CITY OF ALBUQUERQUE

January 22, 2020

Re: 3308 4th St. Apartments
3308 4th St. NW
30-Day Temporary Certificate of Occupancy
Transportation Development Final Inspection
Engineer's/Architect's Stamp dated 6-14-18 (H14D109)
Certification dated 1-16-20

#### 3308 4th SREET, NW SITE PLAN FOR BUILDING PERMIT

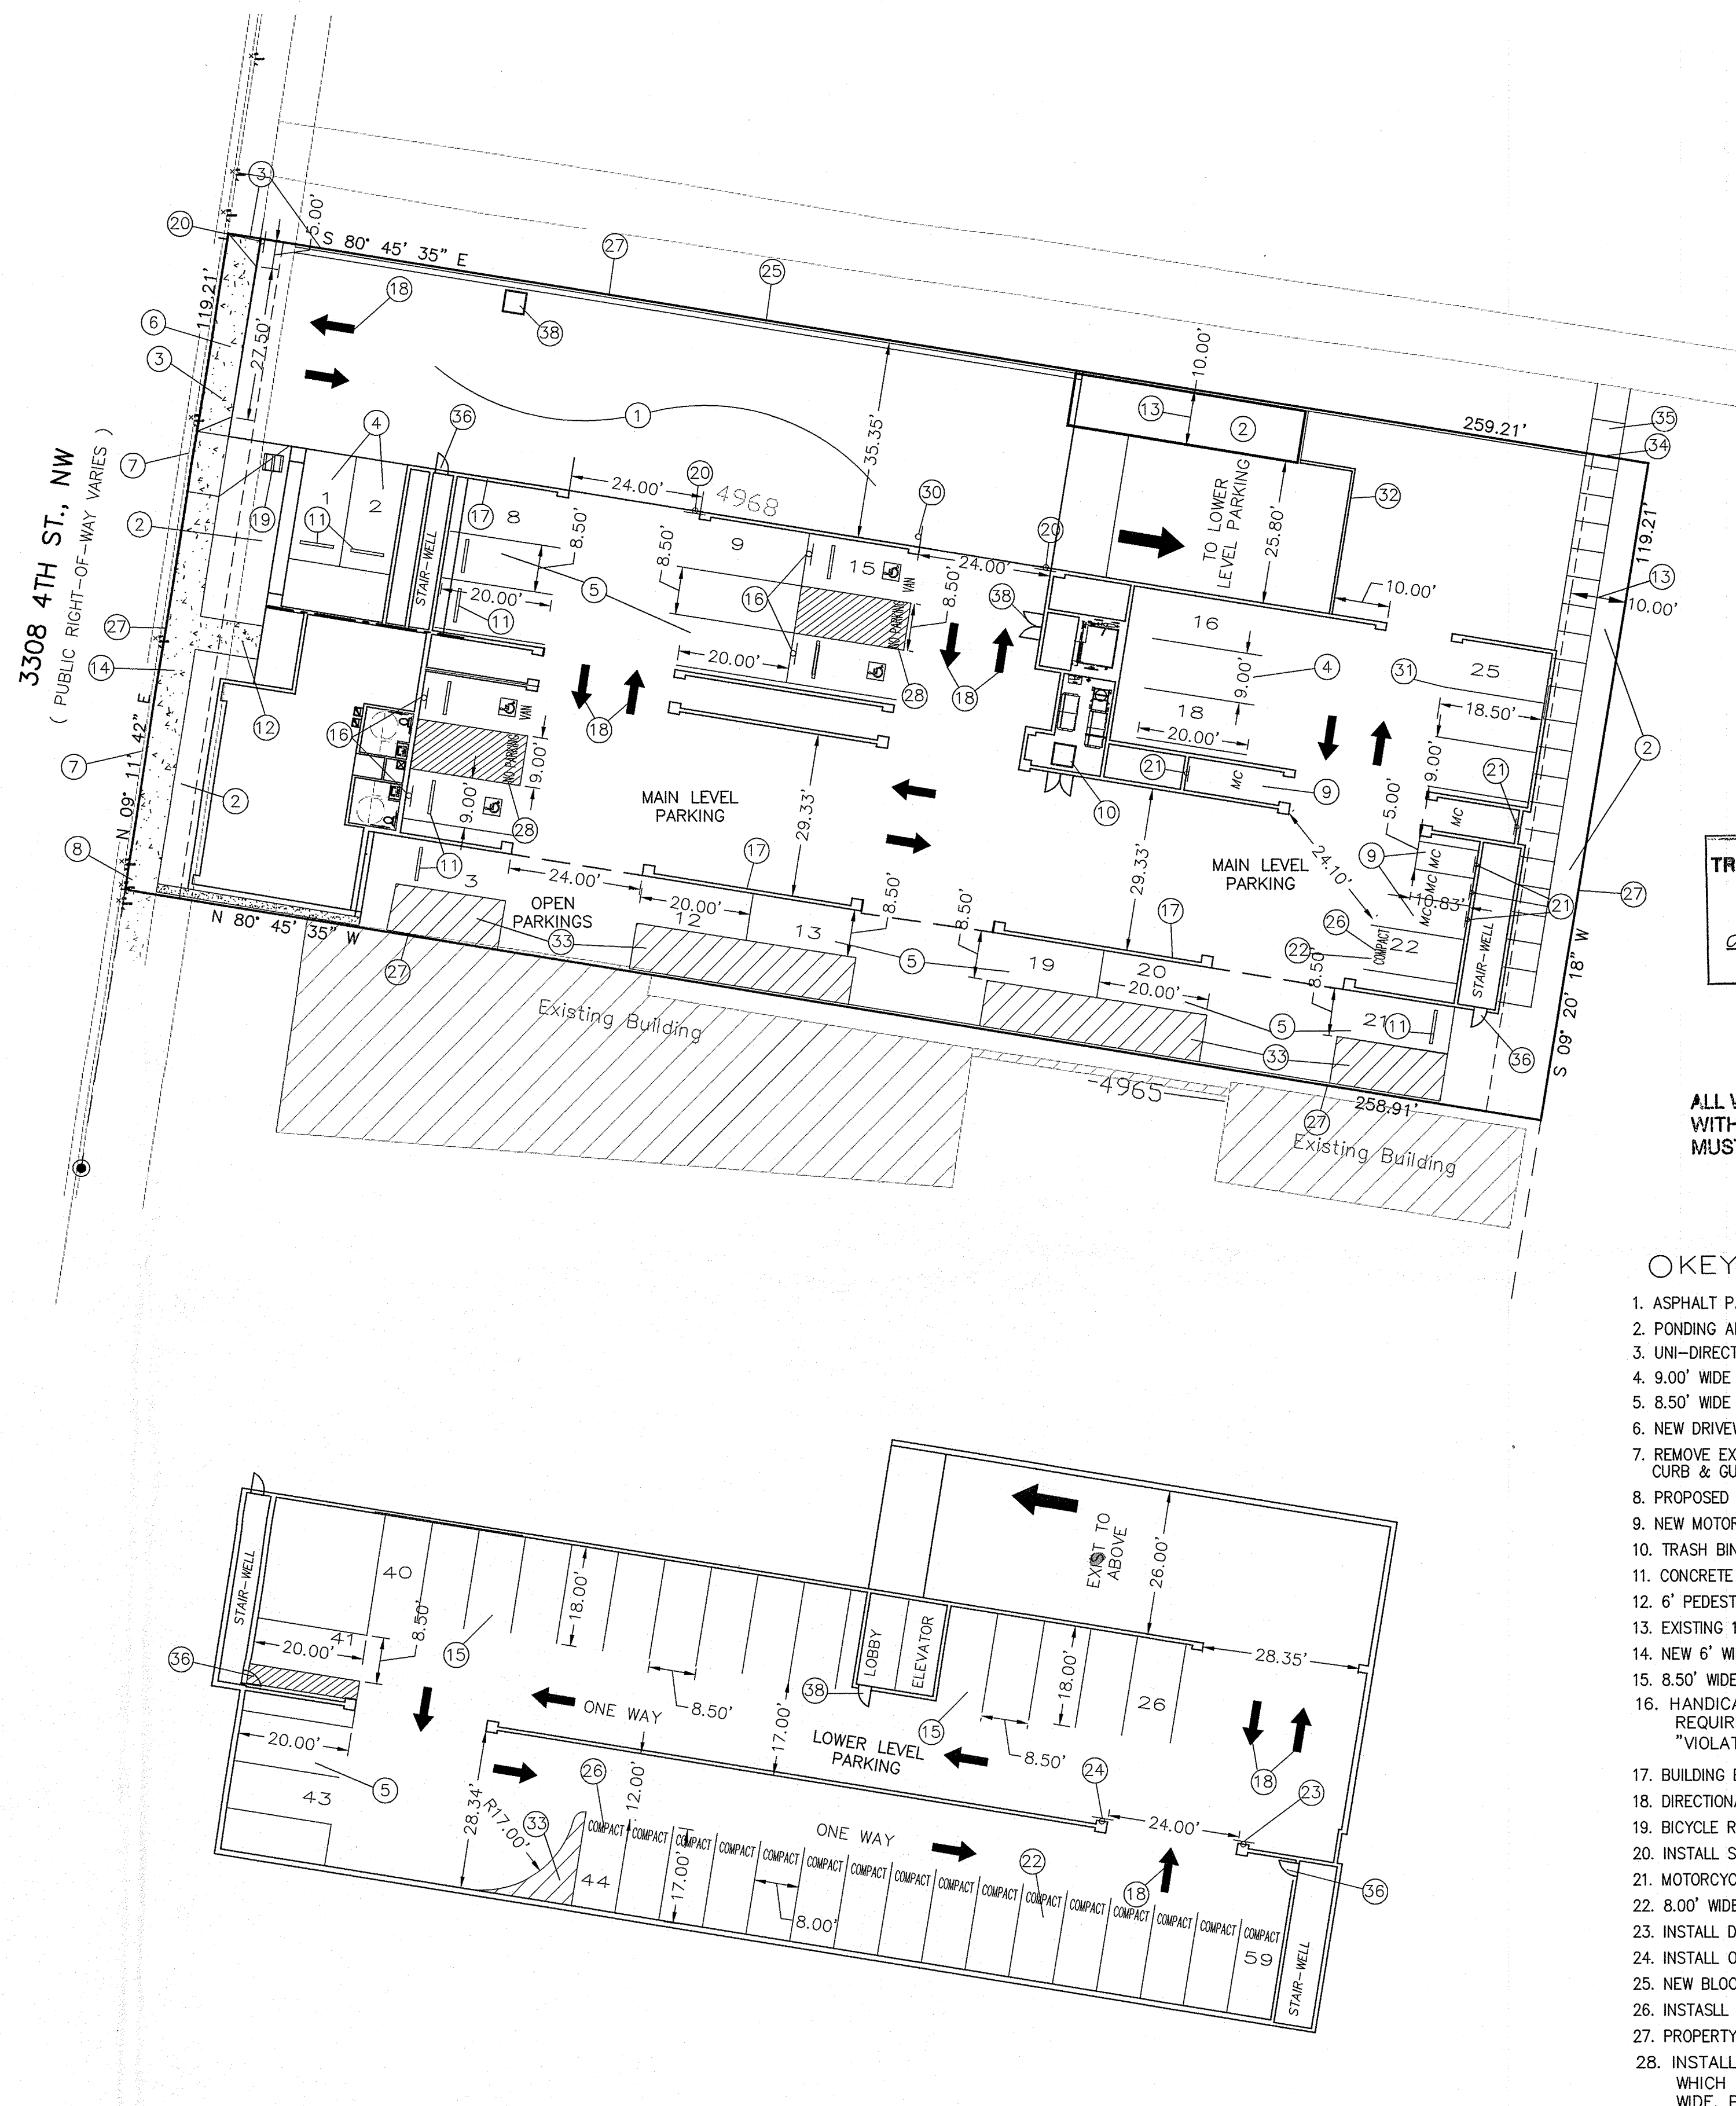
1. Please add motorcycle signs. Each Motorcycle parking space shall be designated by its own conspicuously posted upright sign, either free-standing or wall mounted per the IDO.
2. Please remove construction debris, materials and porta potty.
